COUNTY COUNCIL'S RESPONSE TO CONSULTATION ON THE FOLLOWING DEVELOPMENT PROPOSAL

Application no: 20/03660/REM

Proposal: Reserved matters application to 18/02147/OUT - Erection of 21 dwellings
(consideration of Appearance, Landscaping, Layout and Scale)

Location: Stone Pits, Hempton Road, Deddington

LANDSCAPE MASTERPLAN
HARD AND SOFT LANDSCAPE

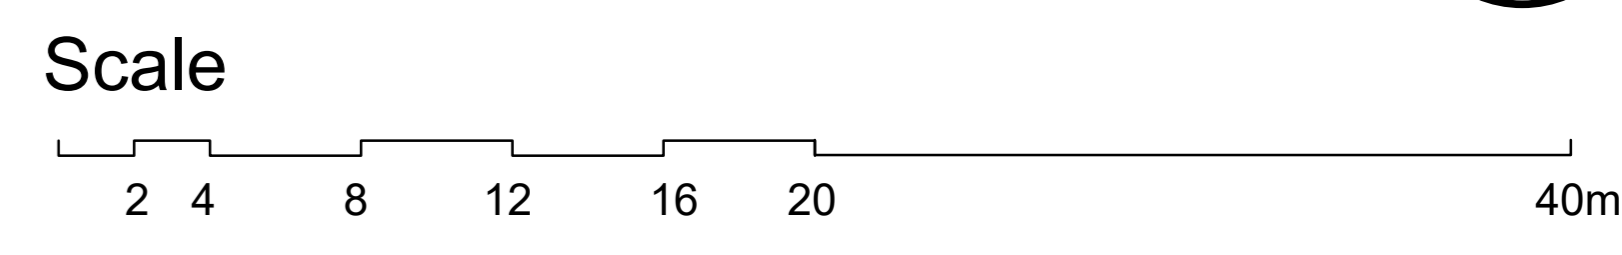
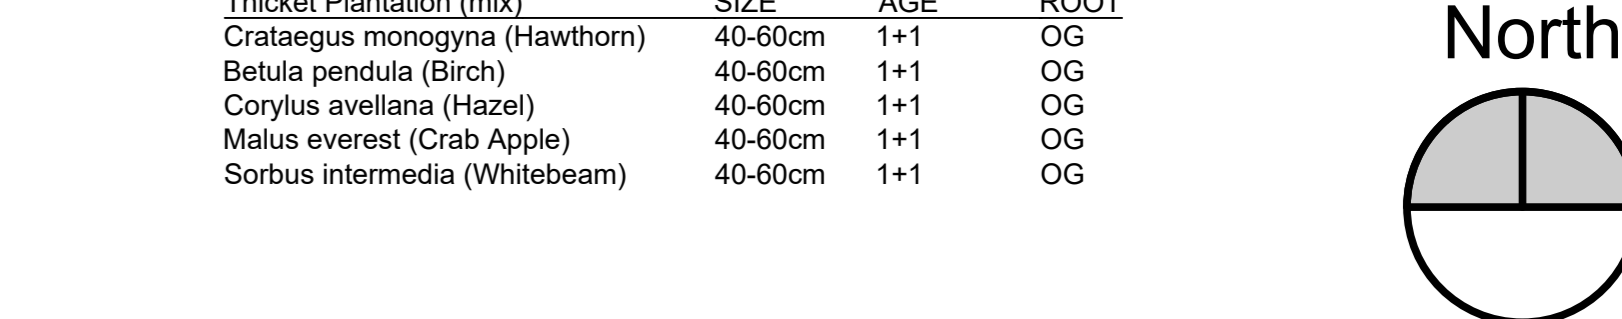
TDC has concerns regarding the parking design arrangement within the proposed layout for the development. Inadequate space appears to have been allocated for cars that may use some of the parking bays for parking manoeuvres. The Applicant has not provided any information or drawing indicating that proposed layout can accommodate the swept paths of Delivery Service and Emergency Service vehicles e.g. a Fire Tender.

The submitted drawing show a cluster of tandem parking arrangement which the Transport Officer does not support because it is generally impractical and inconvenient to use. The dimensions of the double garage appear to be substandard. Also, no provision of parking for persons with impaired mobility or Electric Vehicle Points having be included in the parking arrangement.

- **Car Park Layout Plan**
Prior to commencement of the development, a plan detailing the layout of the car parking area shall be submitted to, and approved by, the Local Planning Authority. The Car Park Layout Plan must set out so that all car parking spaces meet the minimum dimensions required and can be safely and easily accessed and cars that may use them. The Applicant should also ensure that the proposed garages shall be used solely for that purpose on the implementation of the development.
Reason: in the interest of highway safety
- **Cycle Parking**
Before the development permitted is commenced details of the cycle parking areas, including dimensions and means of enclosure, shall be submitted to, and

prior to implementation an updated Fire Tender Plan must be submitted to the Local Planning Authority showing a fire tender can access all parts of the site.

- A scaled and dimensioned car park and internal layout drawing superimposed with the swept paths of car accessing and manoeuvring out of parking bays, and that of Delivery and Emergency vehicles should be submitted for approval by Highway Authority prior to implementation of the above development
